December 5, 2023

**Re: PA23-021 – White Barn Brown Bear Car Wash – Technical Review 1**  
8907 & 8915 Soper Hill Rd – APN(s): 00590700031903 / 00590700031902

After preliminary review of the above referenced proposal, the Planning Division has the following comment(s):

Job Number
22681
Sheet
CWA2.1
of

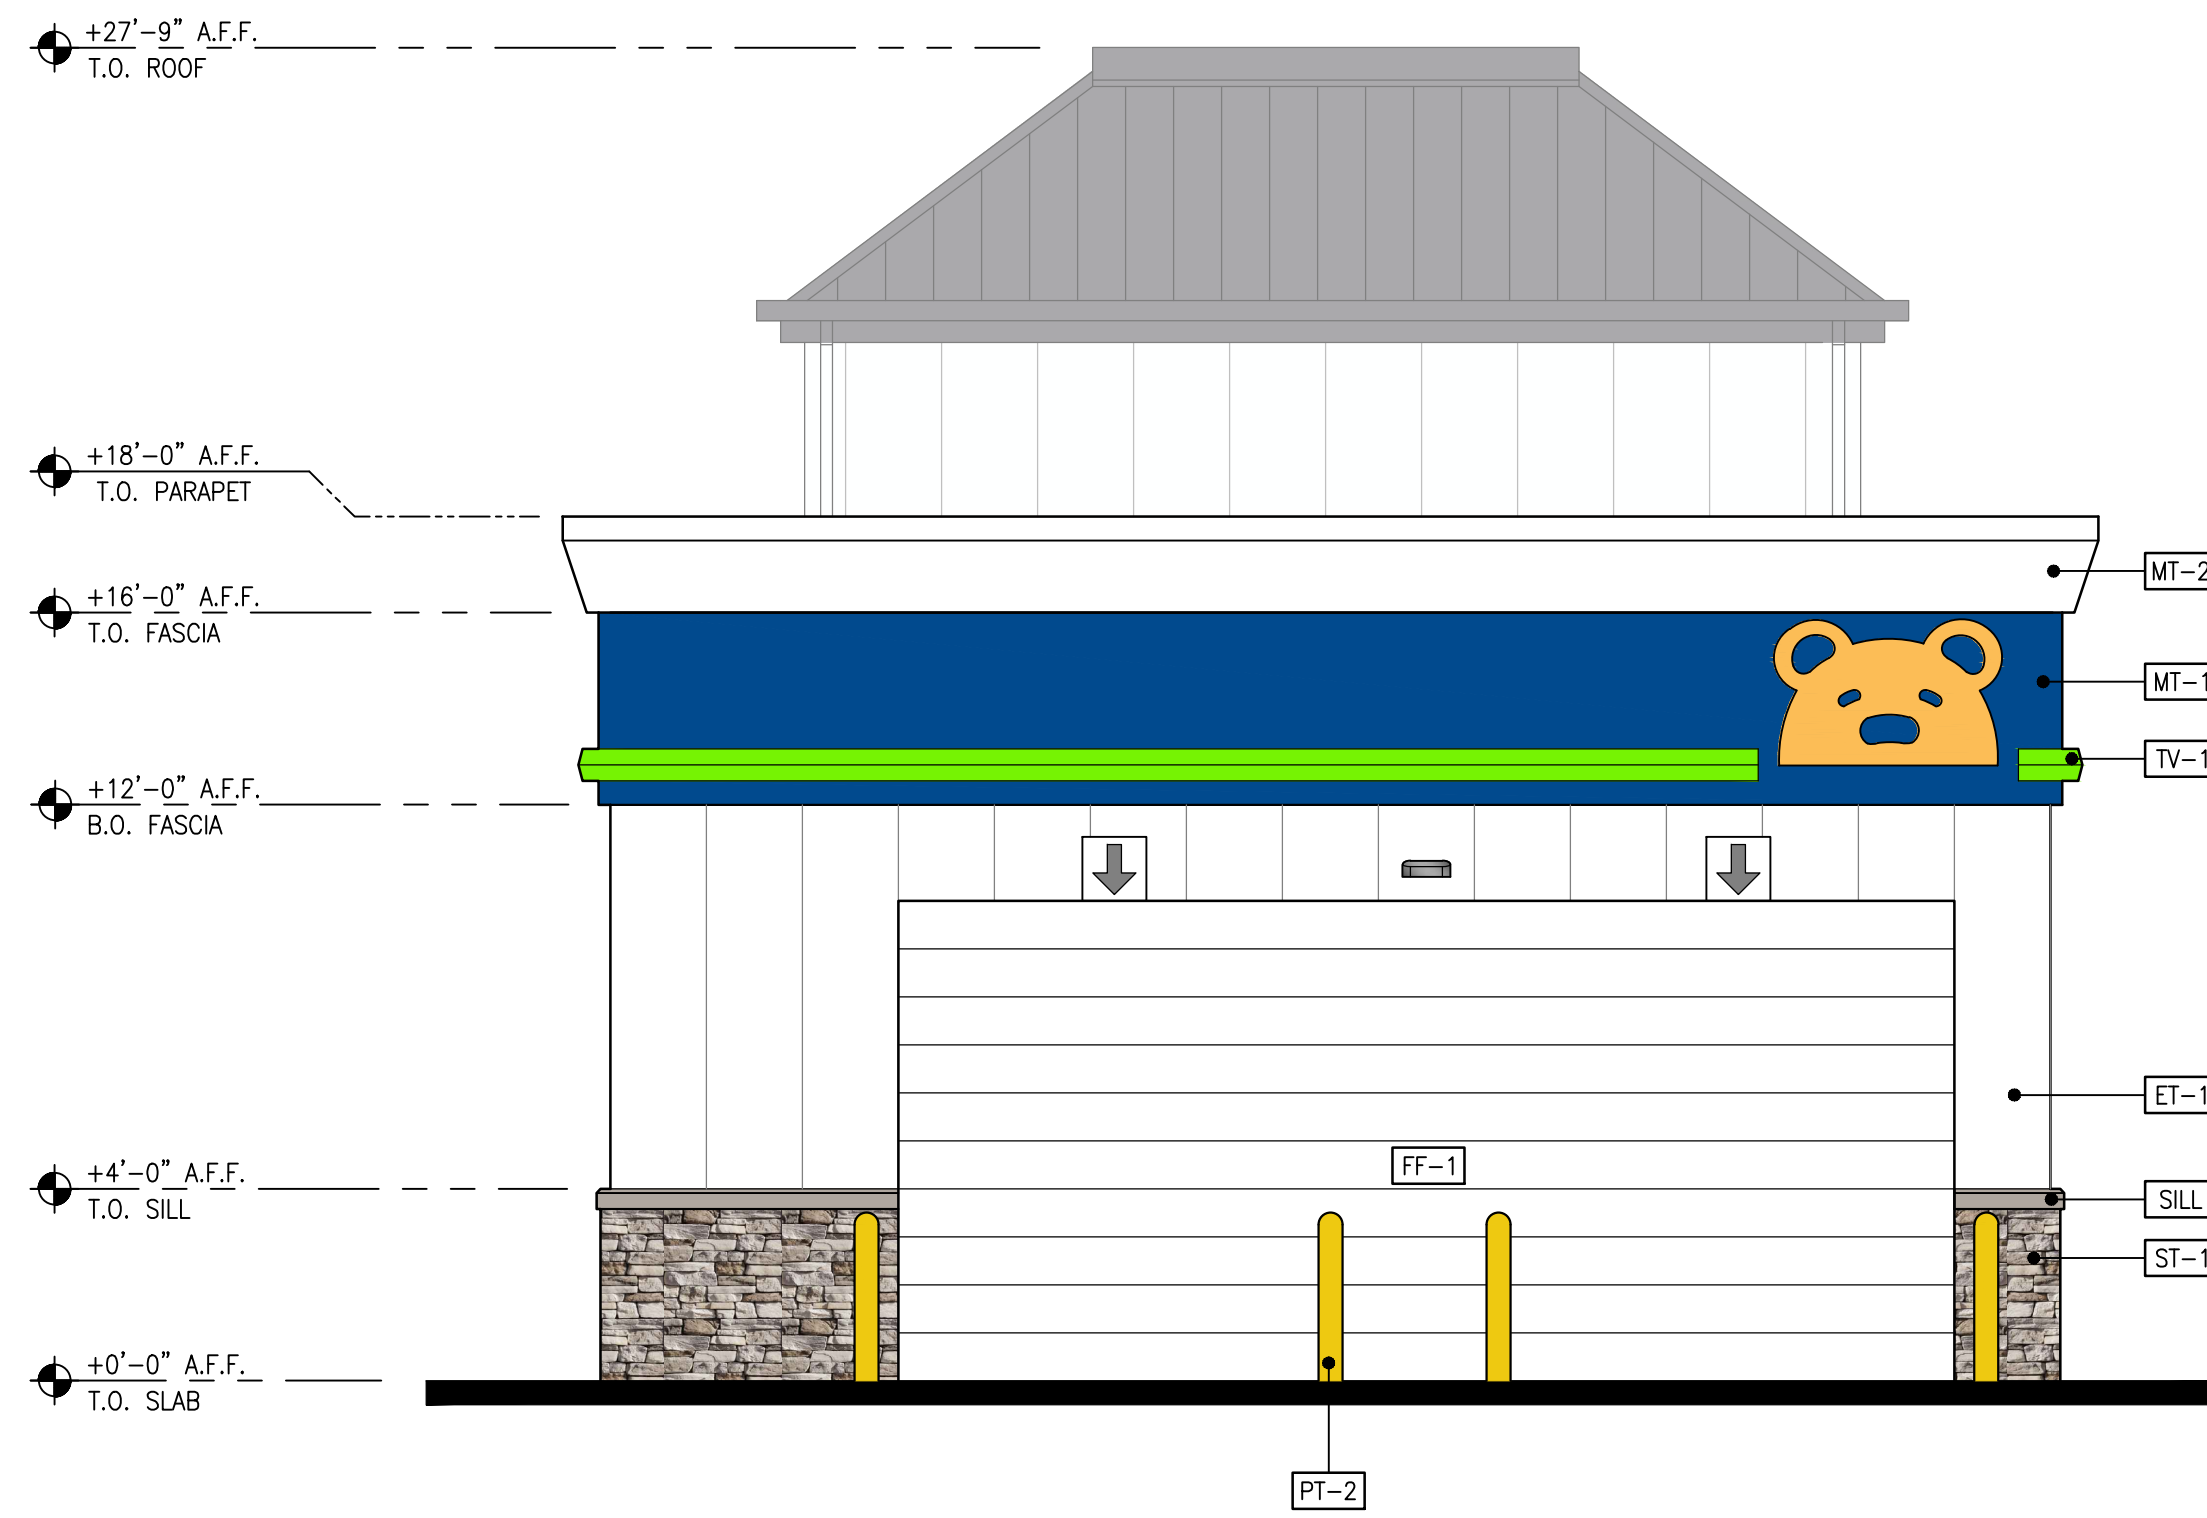
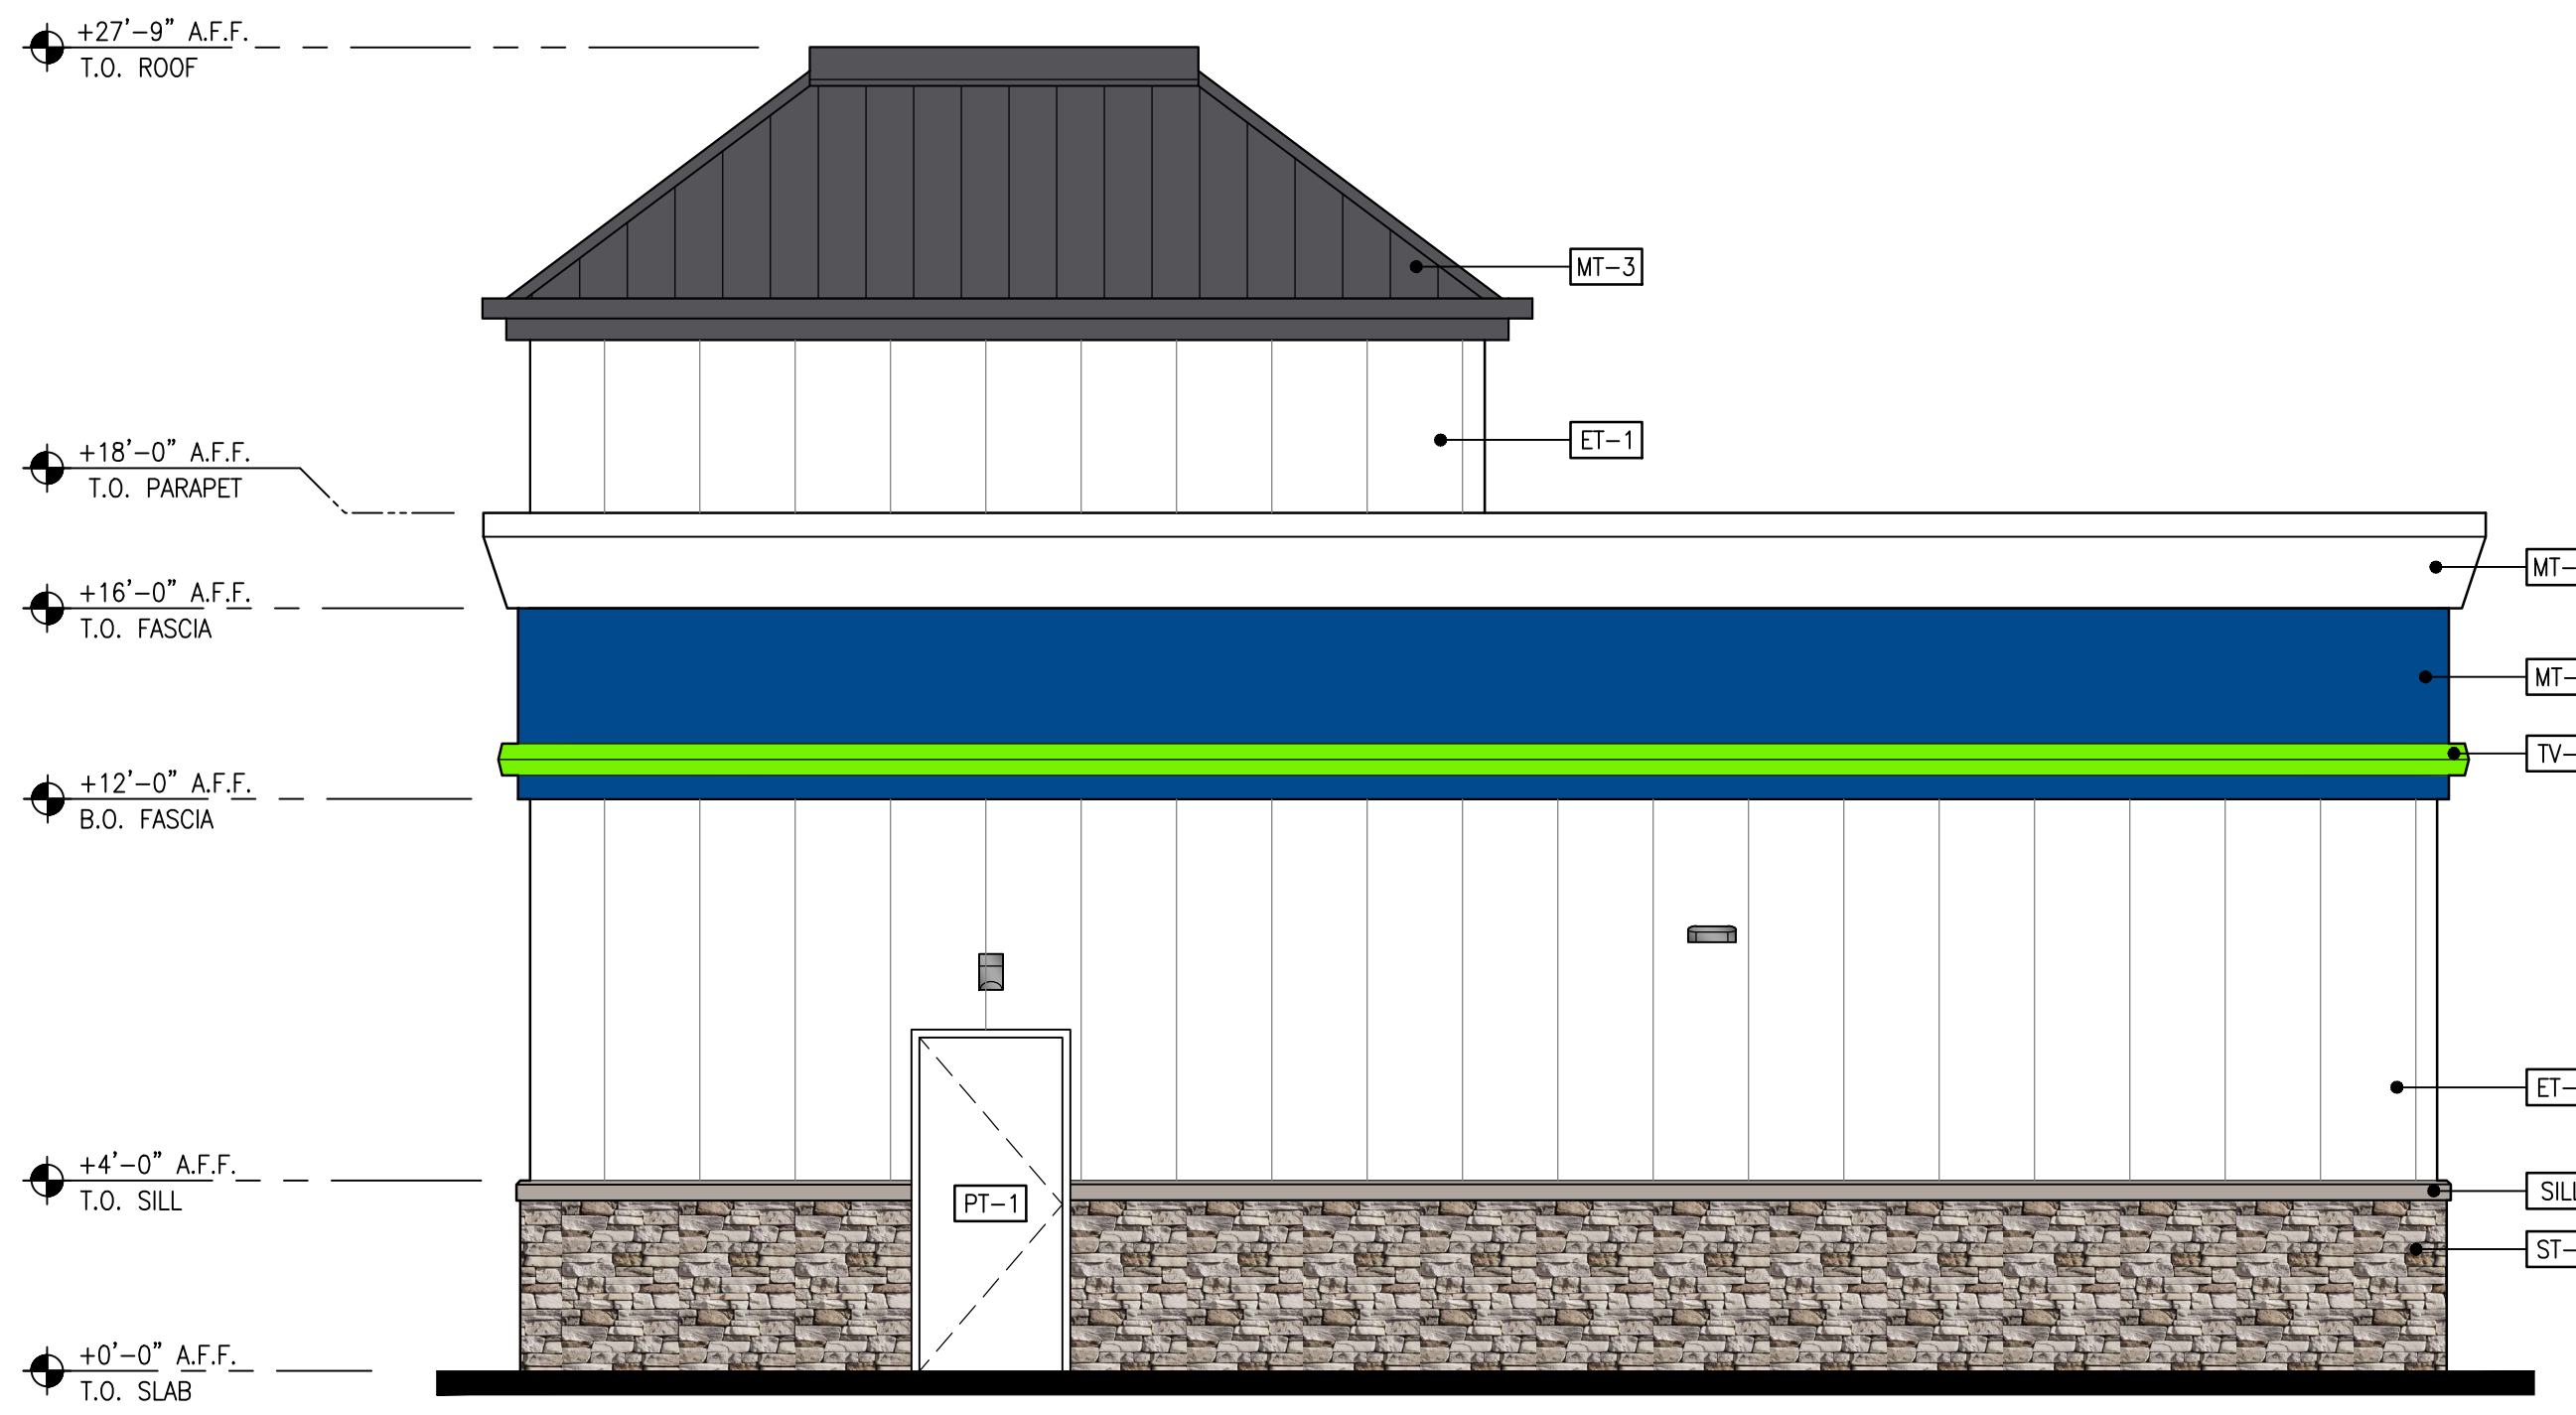
4. To better meet the intent of MMC 2C.070.190(2) in regard to building details standards, architectural design elements should be included the windows and doors (i.e. awnings, trimming, recessed entries, decorative doors etc.).
  - 4.1. Demonstrated compliance with (2)(d) for blank wall treatment is needed. Especially for the east/west elevation of the Self-Wash building.
5. MMC 22C.070.220(2)(f): Rooftop Mechanical Equipment. All rooftop mechanical equipment shall be organized, proportioned, detailed, screened, landscaped (with decks or terraces) and/or colored to be an integral element of the building and minimize visual impacts from the ground level of adjacent streets and properties. Demonstrated compliance will be needed.

# PRELIMINARY LANDSCAPE PLAN

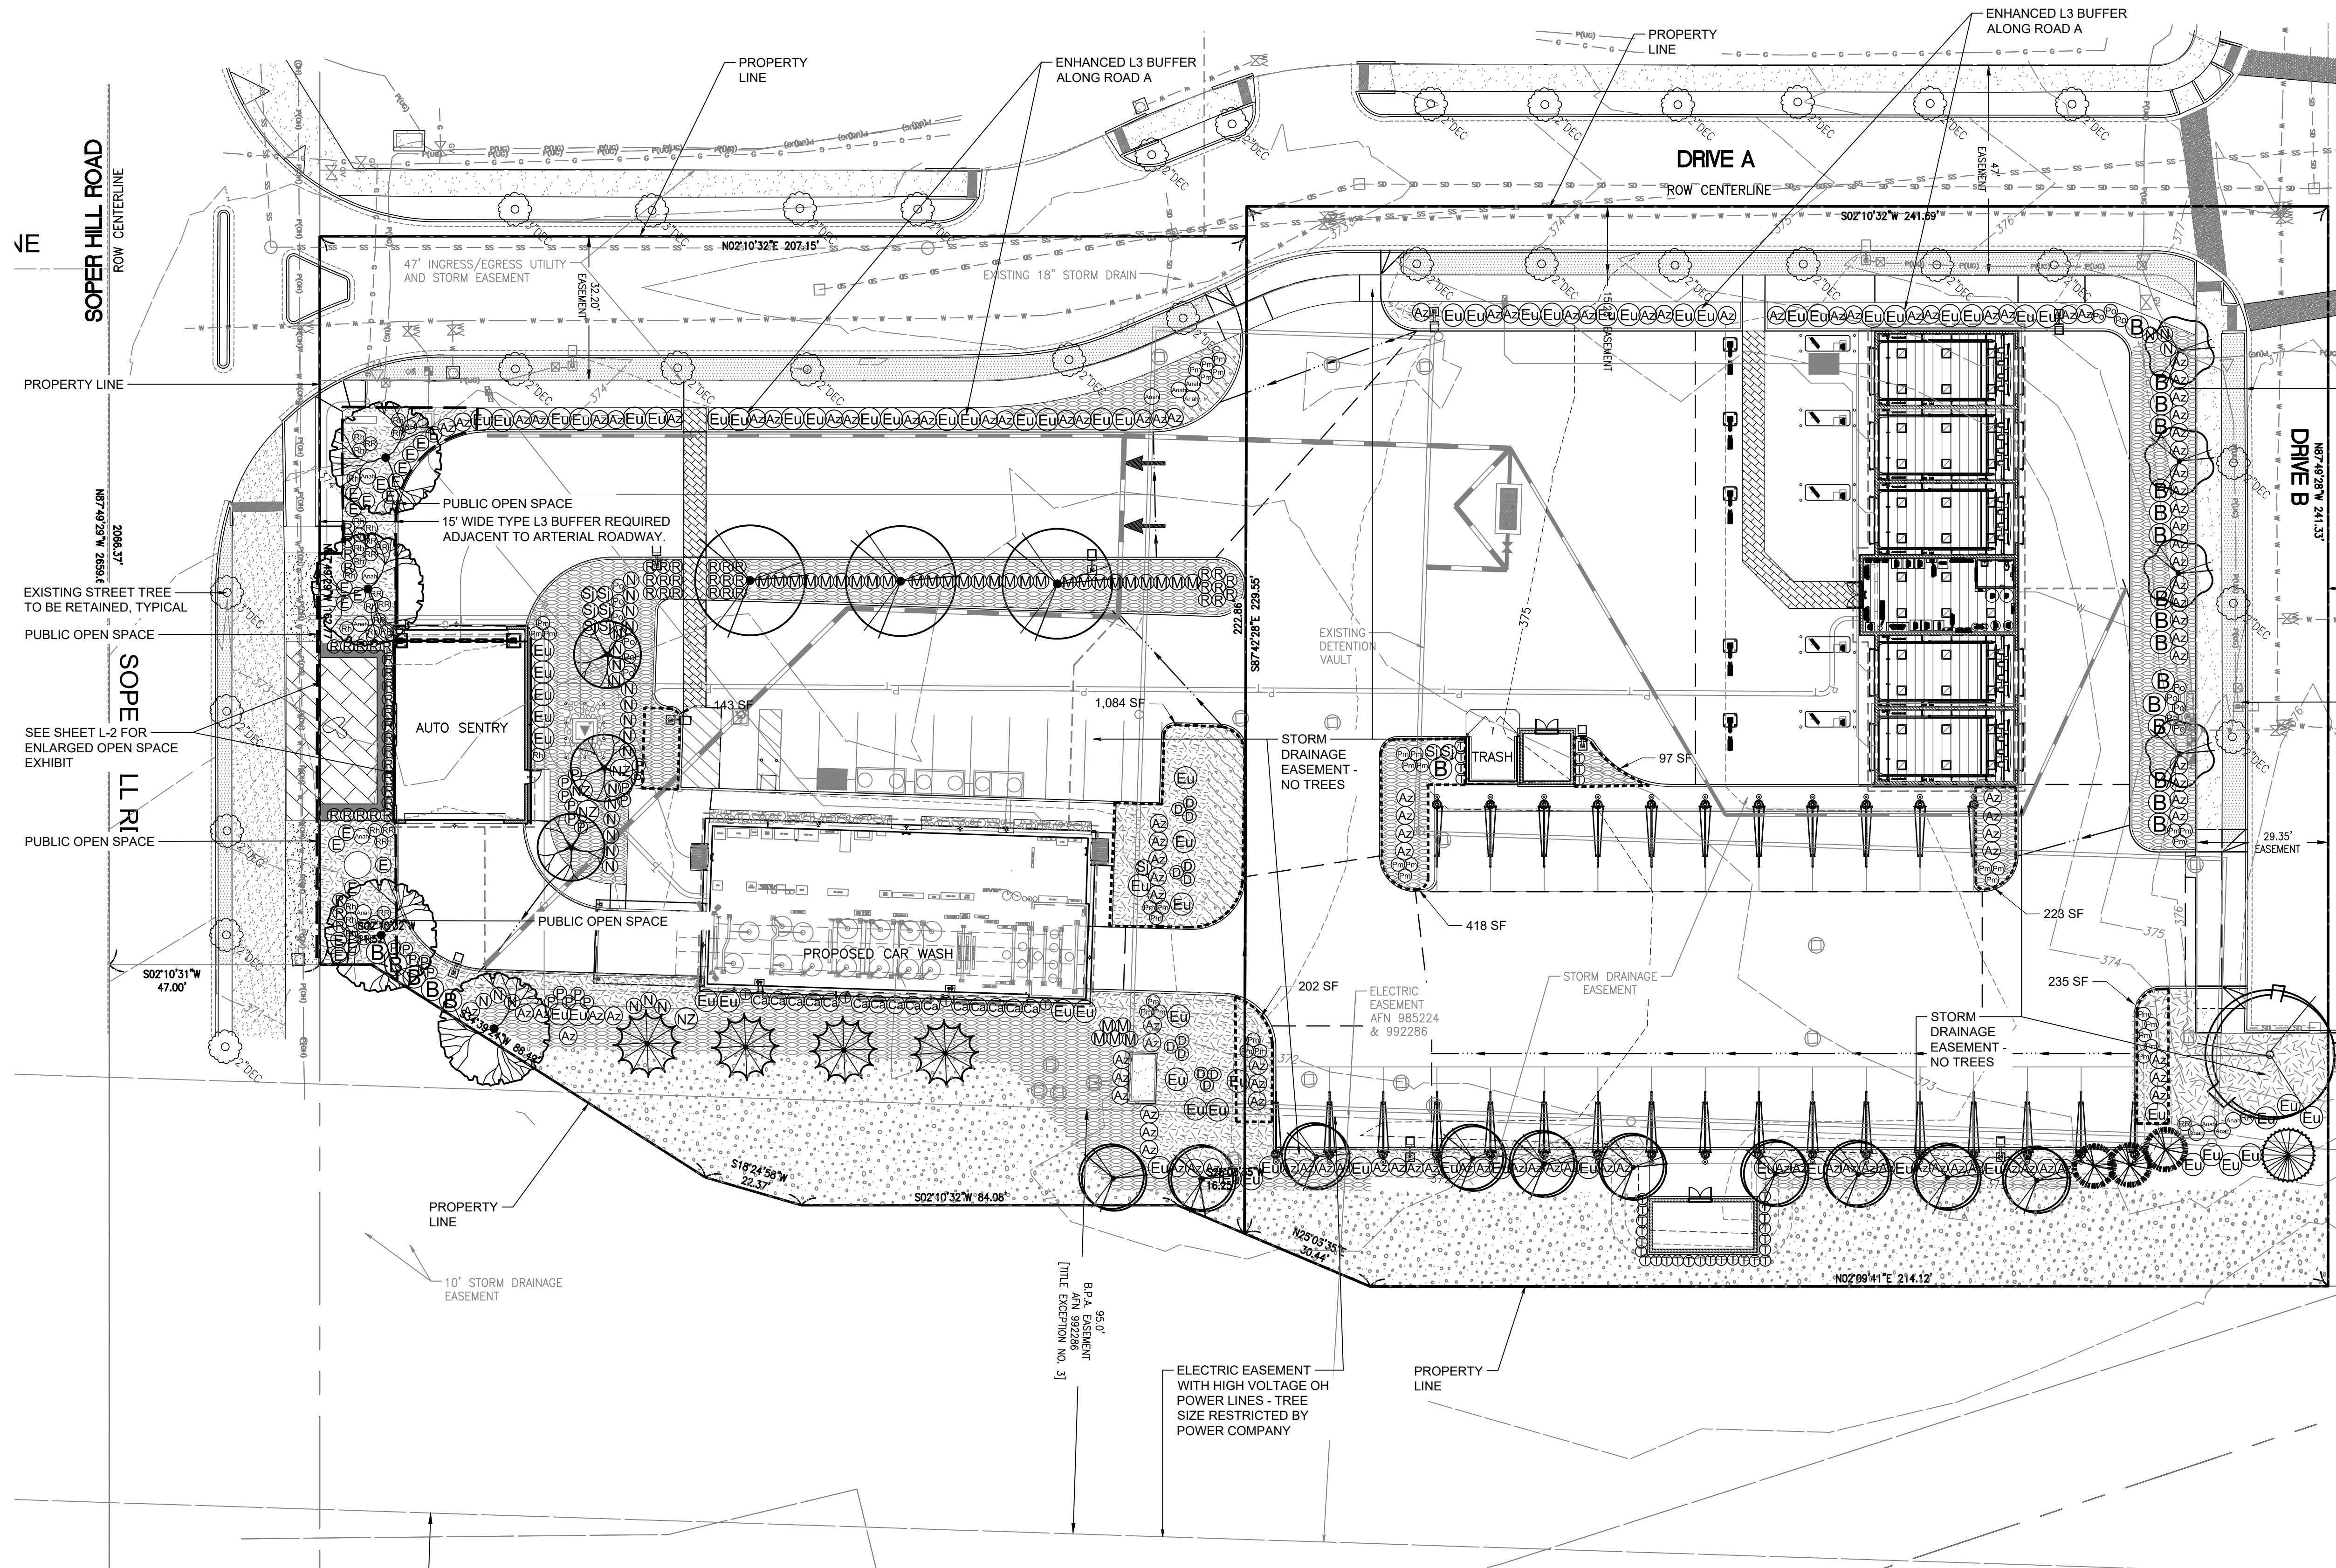
6. Pursuant to MMC 22C.070.210(2)(a)(ii), parking lots adjacent to internal roadways must provide a 20 ft. landscaped planting strip to provide screening. Because the western boundary is for parking and vehicle queueing, adequate screening is required. Per section (iv) of the previously referenced section, the director may allow deviations from this section if the alternate design meets the intent of this section. As proposed, this area would not meet the requirements.
7. 10 ft. buffer of L3 landscaping is required along Drive A and Drive B. The provided landscape plan does not appear to propose a buffer that would adequately meet the intent of this requirement.
8. Provide a typical elevation view of the required perimeter buffer landscape areas.
